**From:** [REDACTED]  
**Sent:** 03 June 2024 17:00  
**To:** Planning  
**Subject:** Planning Application 3/2024/0302

Reference: Revised Planning Application No 3/2024/0302.  
Previous Planning Refusal Appeal Decision AAP/T2350/W/23/3321409.

SHEET:  
**PROPOSED SITE PLAN &  
CONTEXT SHEET**

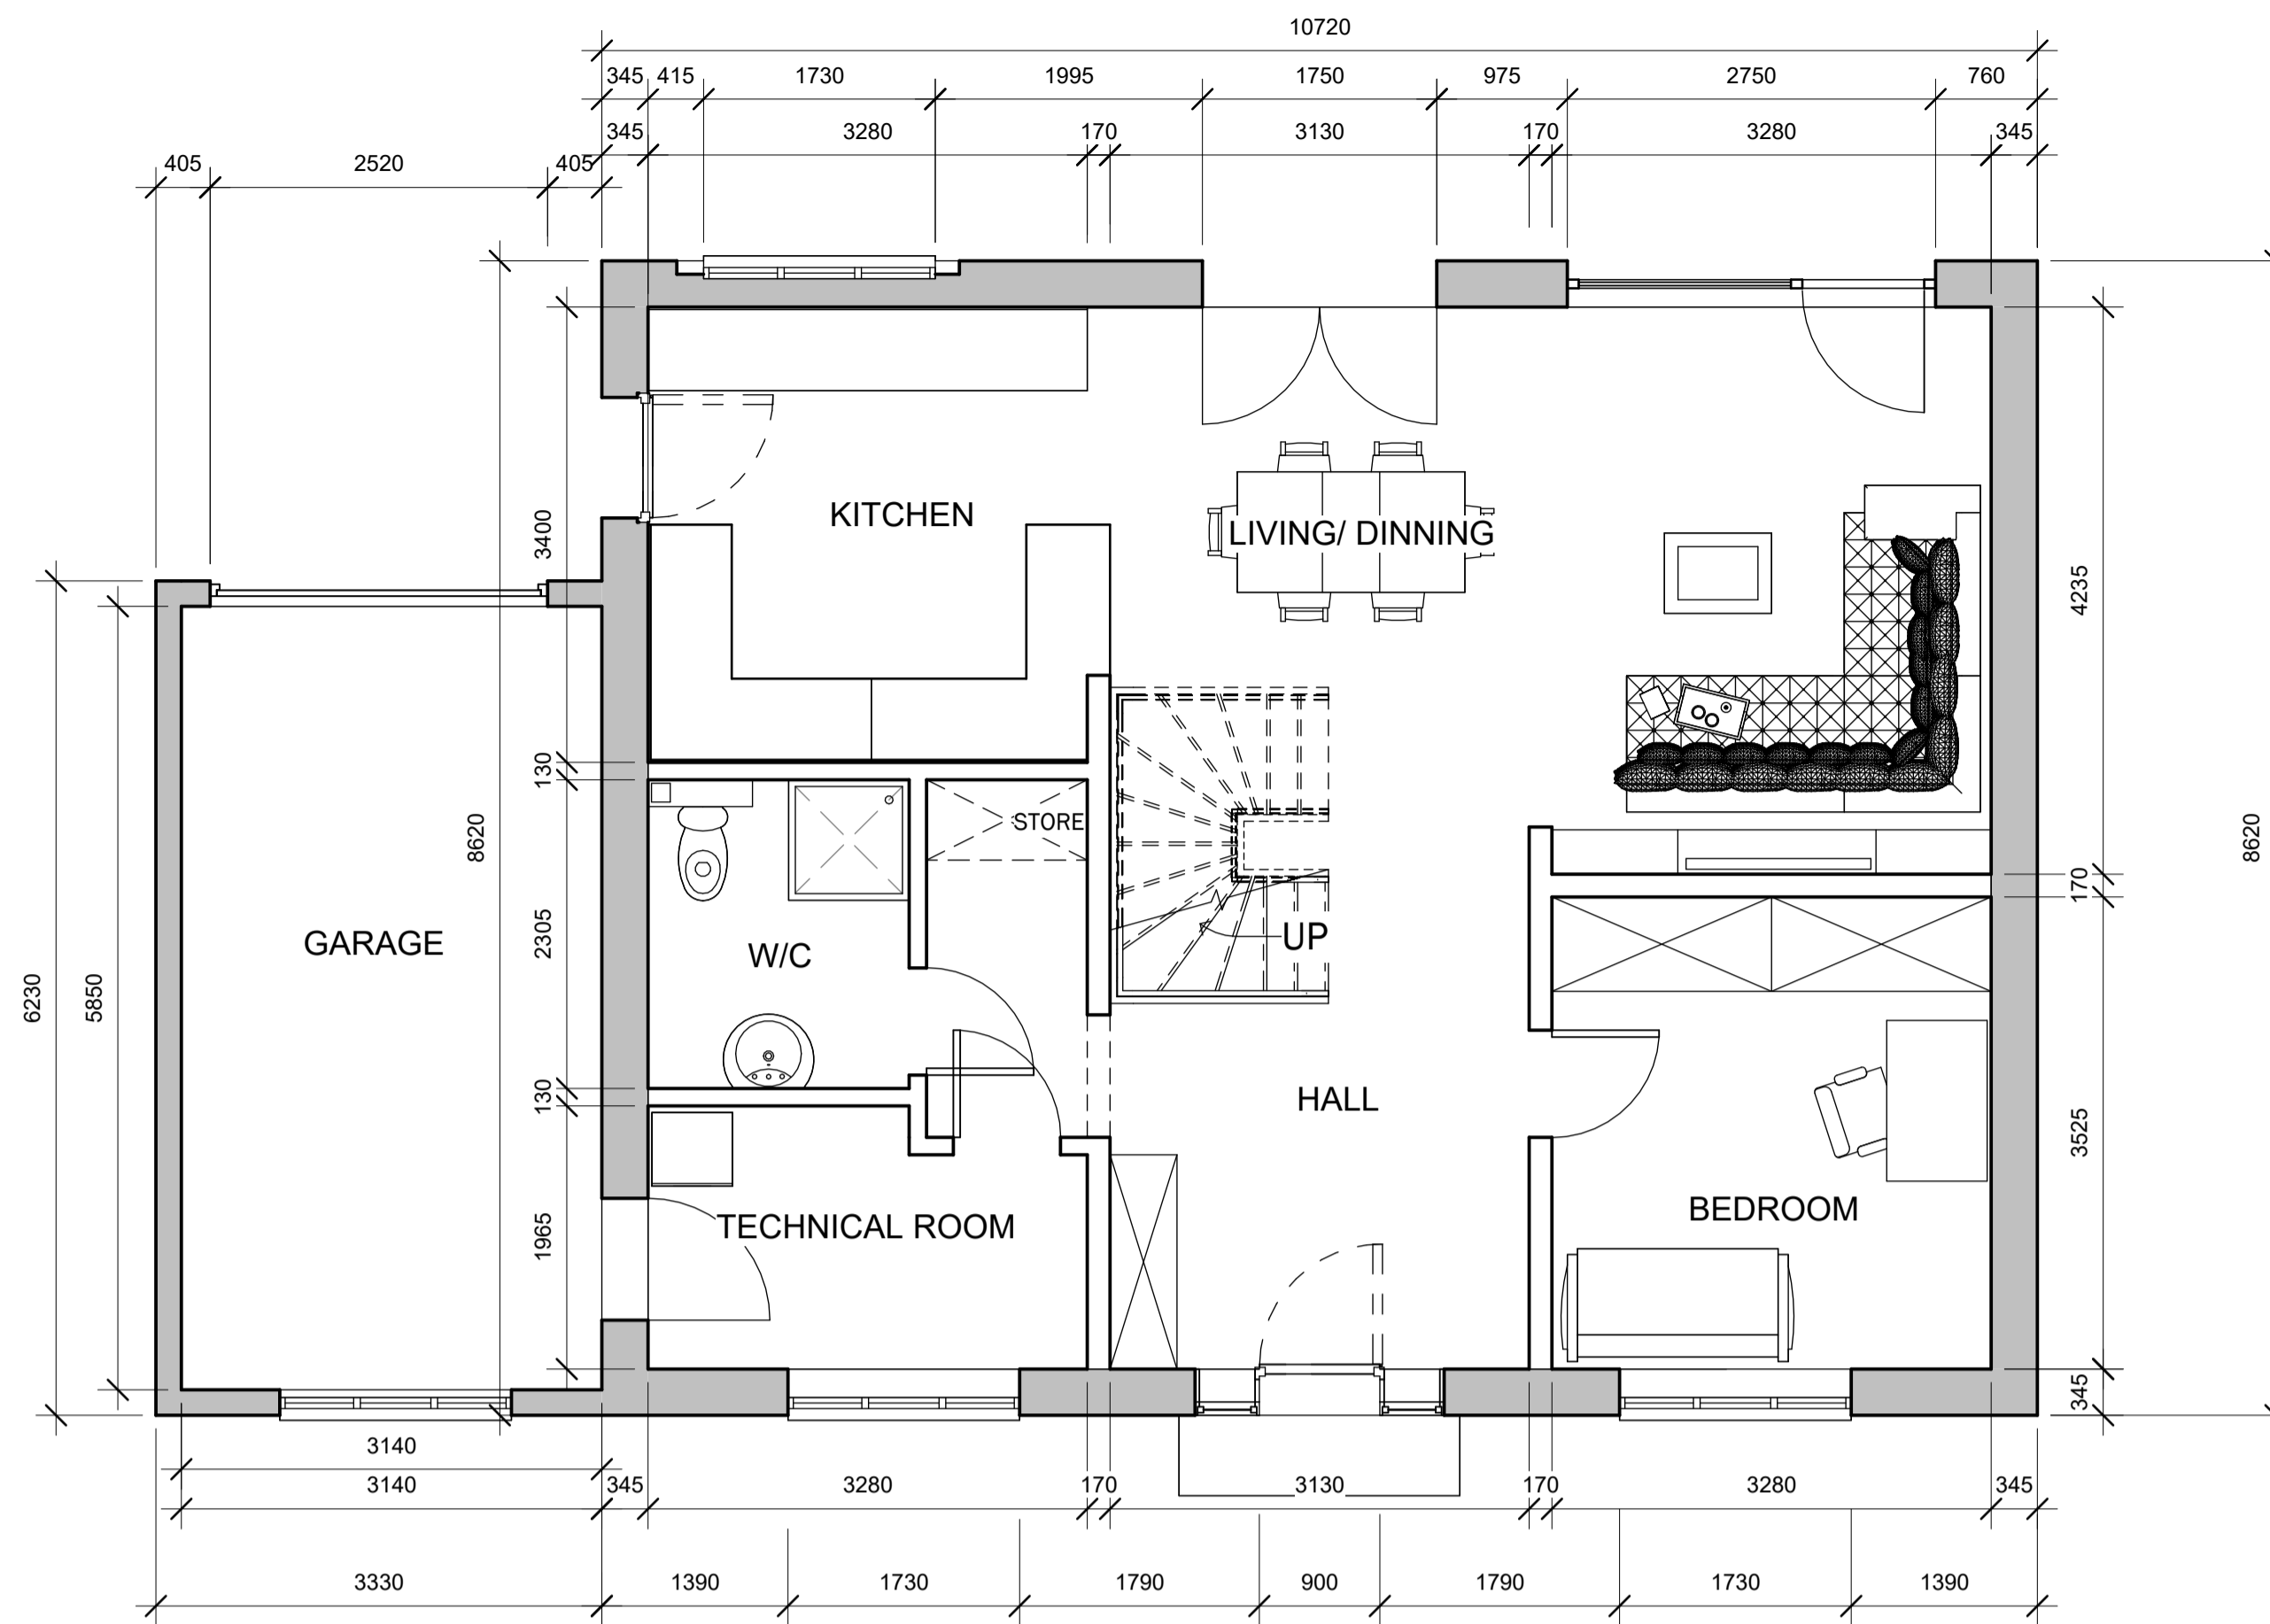
There is a serious communication concern relating to a proposed soakaway near the North facing existing stonewall, the area is heavily clay based, and borders private farmland, and would be open to a serious risk of flooding and pollution to the Landowner, as mentioned in previous representations, (has there ever or will there be a dug infiltration test??) and contradicts the applicants stated intentions of surface water to be drained into the existing sewer.

The Westerly facing vastly overgrown hedge (over 3 mtrs high) adjacent to an existing stone wall, which the applicant intends to remove, would significantly compromise the integrity and structure of the existing stone wall between two properties.

The outbuilding (formally 98, Ribchester Road) is to be demolished, there are no plans to incorporate areas to store and aid collection of waste, and no arrangements for separate storage and collection of recyclable waste.

The applicant has no control over the parcel of land fronting 102, Ribchester Road , (which the applicant is well aware) as mentioned in previous applications, and over the years has been adopted for well over 10+ years is regularly maintained and landscaped.

PROPOSED ELEVATIONS 1

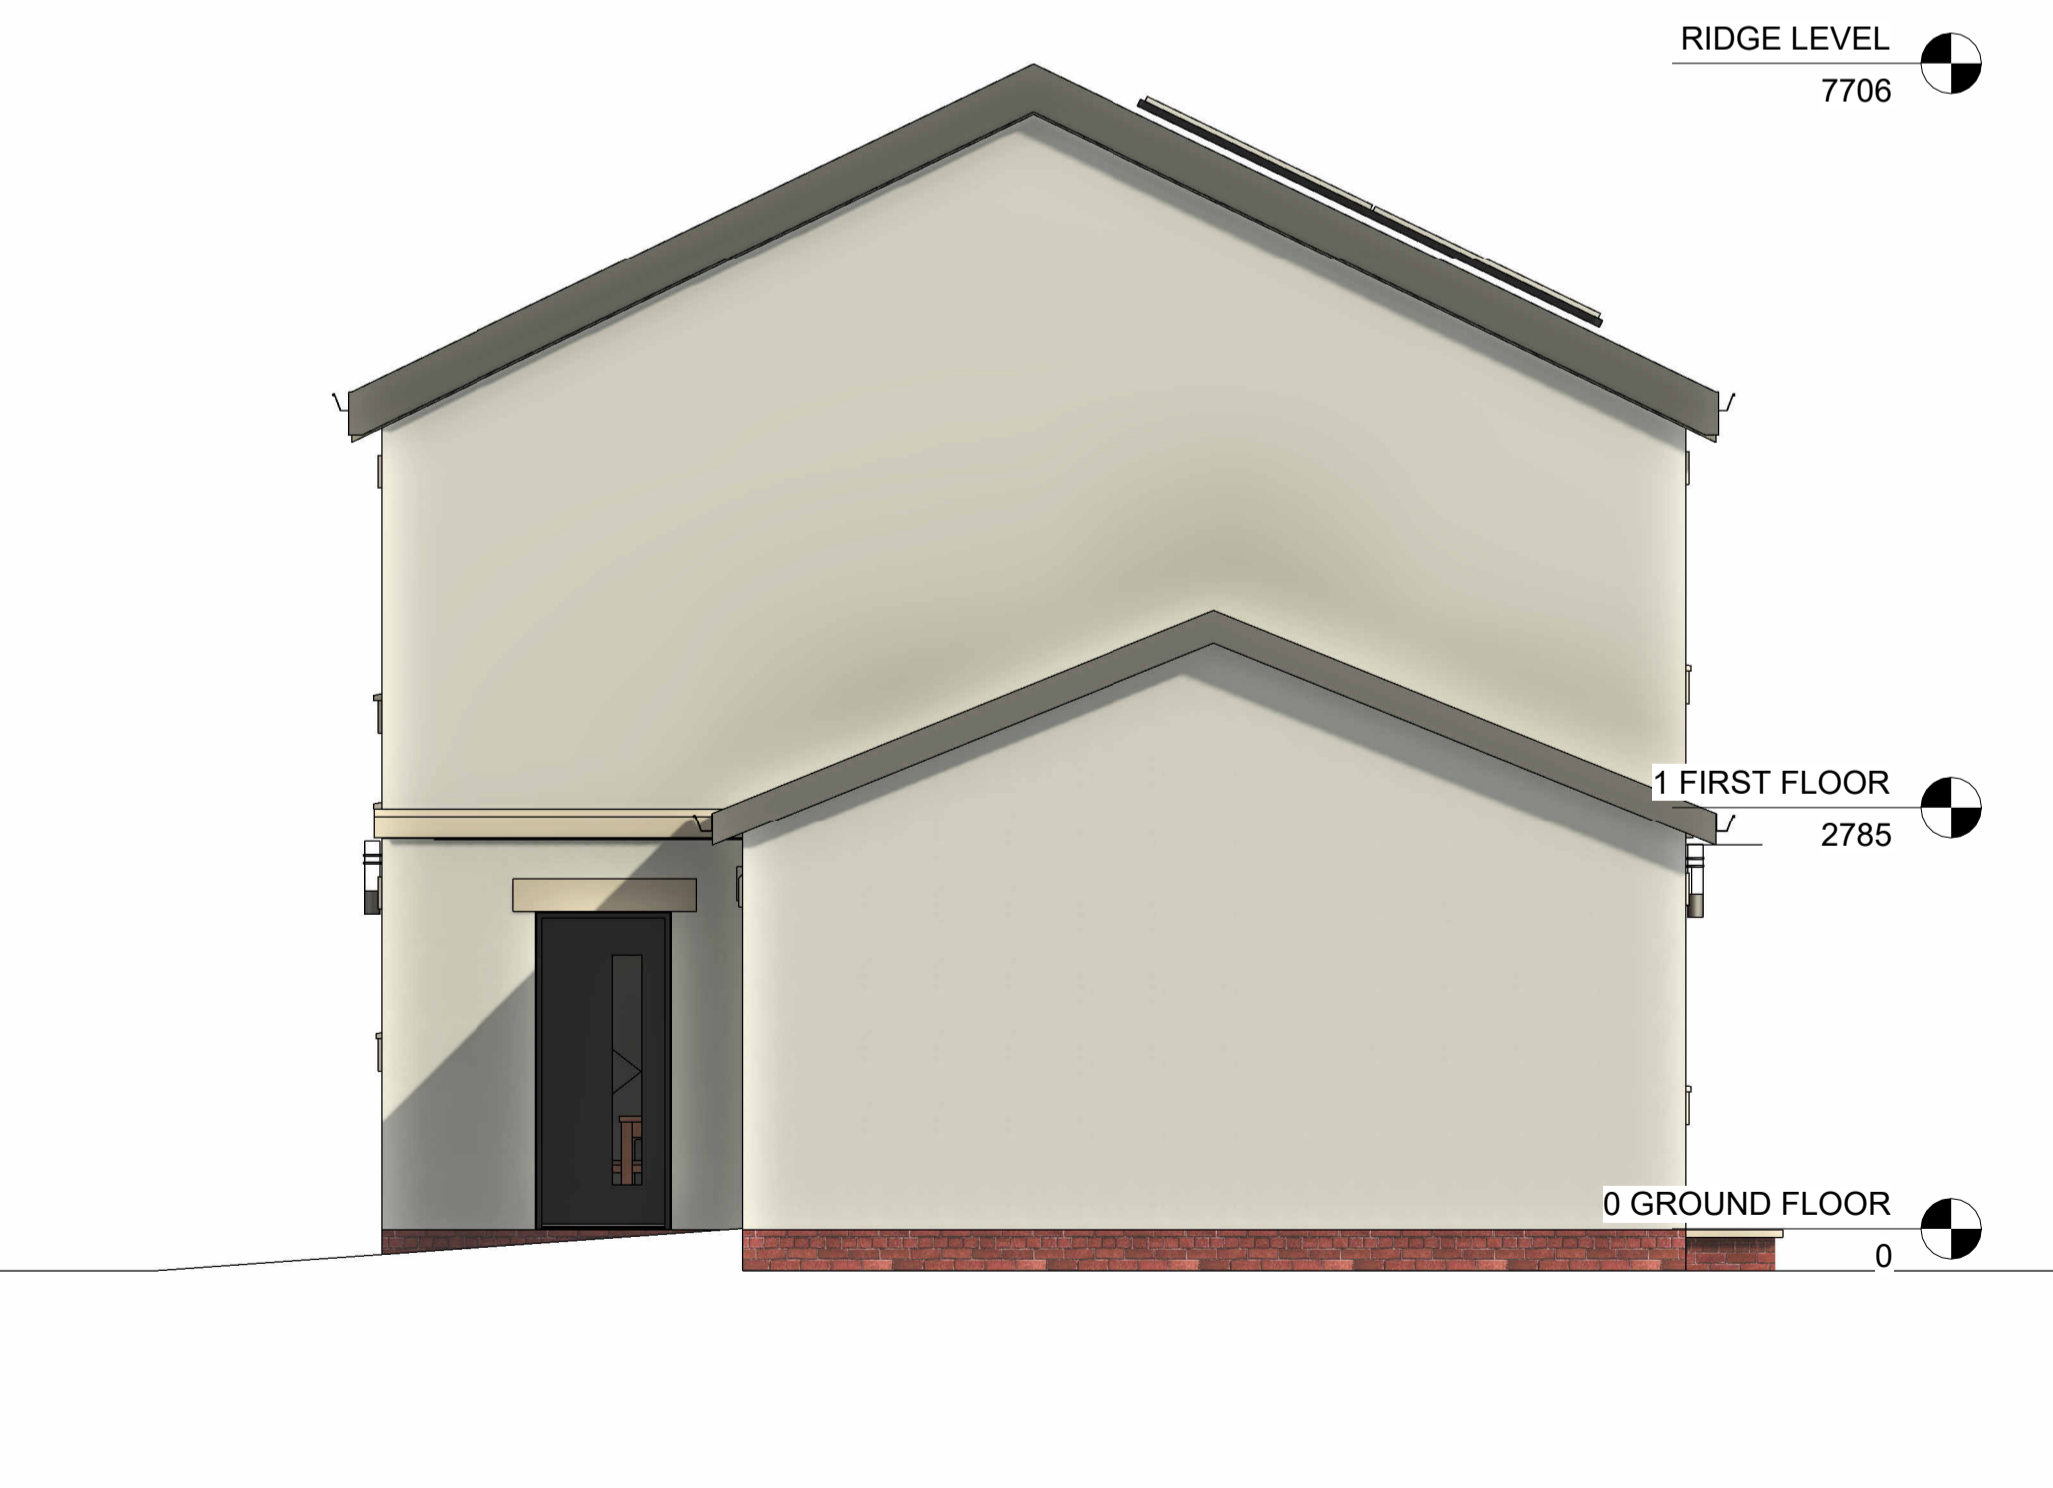
The proposed revised planning referenced above (one of many), again is flawed and discredits the previous dismissed appeal decision AAP/T2350/W/23/3321409 referenced above.  
"With regards to the appearance, layout and scale the proposed dwelling would need to reflect the existing characteristics of the terraced cottages in terms of roofscape"
